From: Plater, Roger - Communities
Sent: 09 December 2021 10:50
To: Lewis Knox
Cc: Transport CDC Minor; DC Support; Cllr George Reynolds
Subject: 21-03197-F Lane Head Main Street Sibford Gower

Planning application:	21/03197/F
Location:	Lane Head Main Street Sibford Gower OX15 5RT
Description:	Demolish existing garage for replacement with oak framed carport and roof alterations to create first floor over existing ancillary outbuilding to create pool and annexe accommodation - re-submission of 21/01535/F
Type:	Full Development
Case Officer:	Lewis Knox

Drawing Title:
 Proposed Elevations

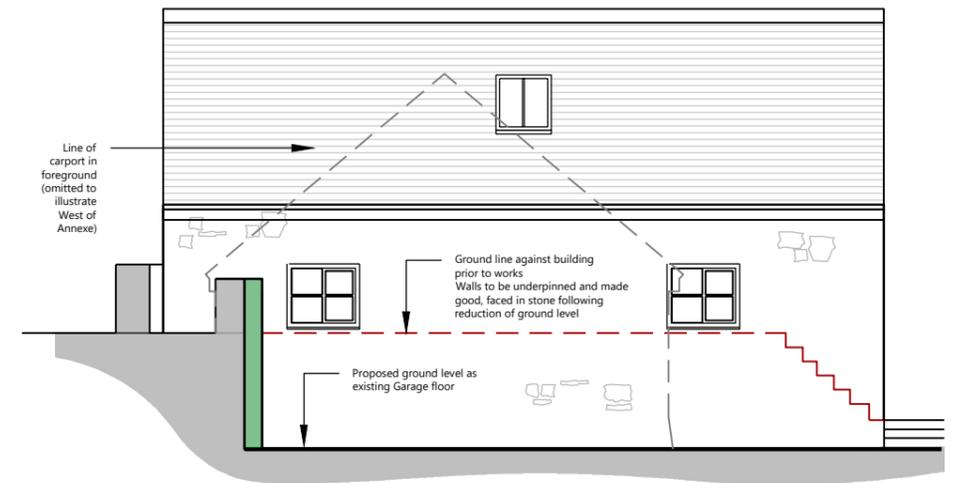
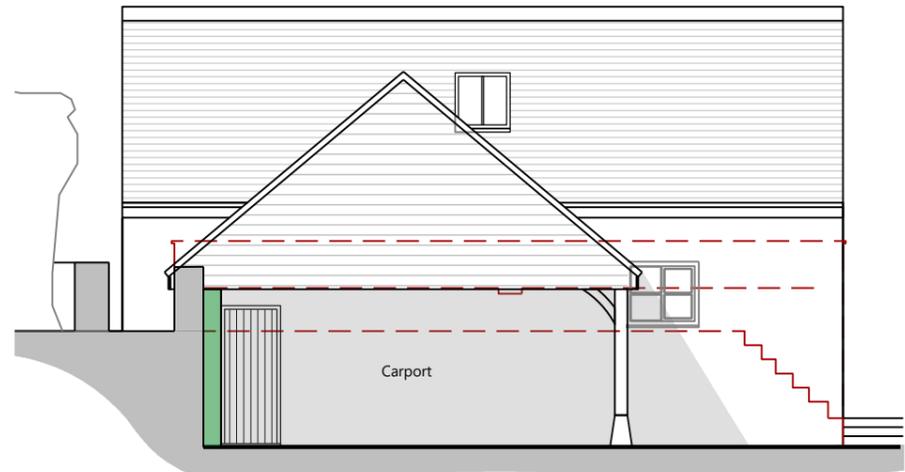
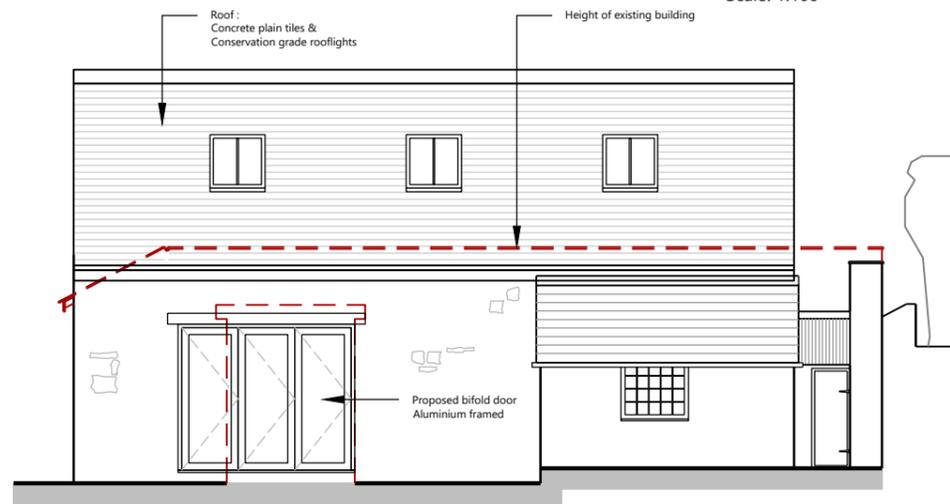
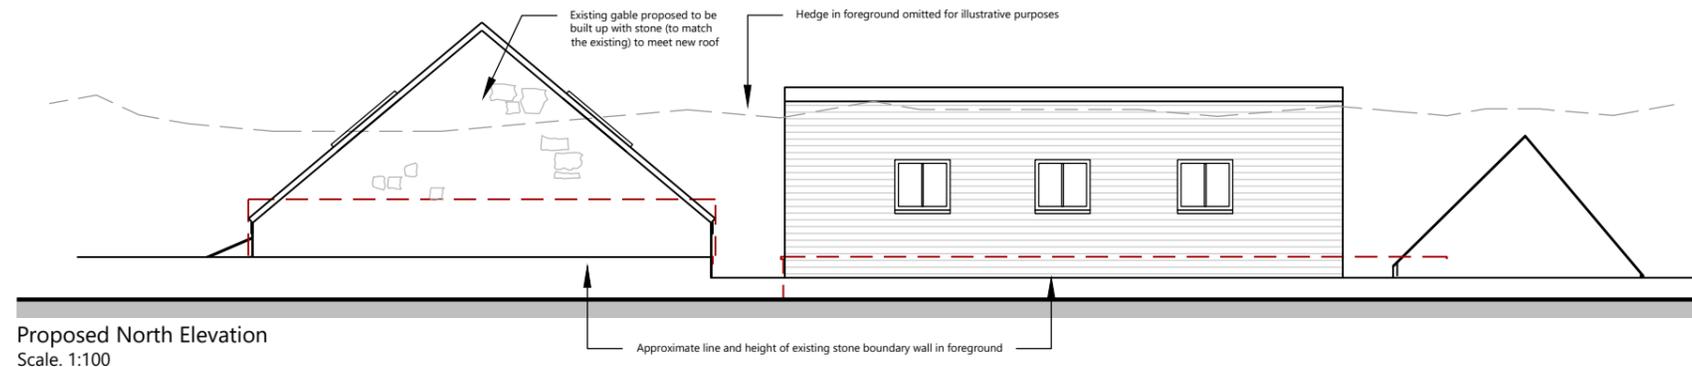
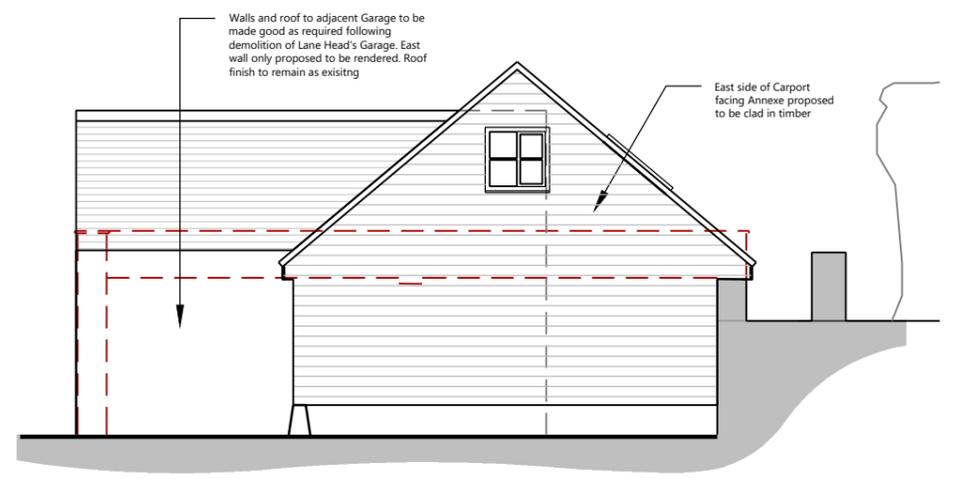
Opening up the carport building will mean that it will be far more likely to be used for the parking of vehicles than the existing garage. This is likely to reduce the instances of on-street parking along the lane which may cause a degree of obstruction, and will create an area in front of the carport where cars may turn.

As I have been assured that it can be conditioned for the annexe to remain ancillary to the main dwelling (Lane Head), modifications to the annexe building will not result in any significant additional vehicle movements, and therefore I see no justifiable reason for objection. This differs from the previous refused application, 17/00608/F, which the LHA objected to, as that was for a new standalone dwelling that would have generated additional movements.

That the Annexe accommodation remains ancillary to the main house only and may not be let or sold as a separate dwelling.

Prior to the commencement of the development hereby approved, a plan showing car parking provision for vehicles to be accommodated within the site, shall be submitted to and approved in writing by the Local Planning Authority. Thereafter, and prior to the first occupation of the development, the parking spaces shall be laid out, surfaced, drained and completed in accordance with the approved details and shall be retained for the parking of vehicles at all times thereafter.
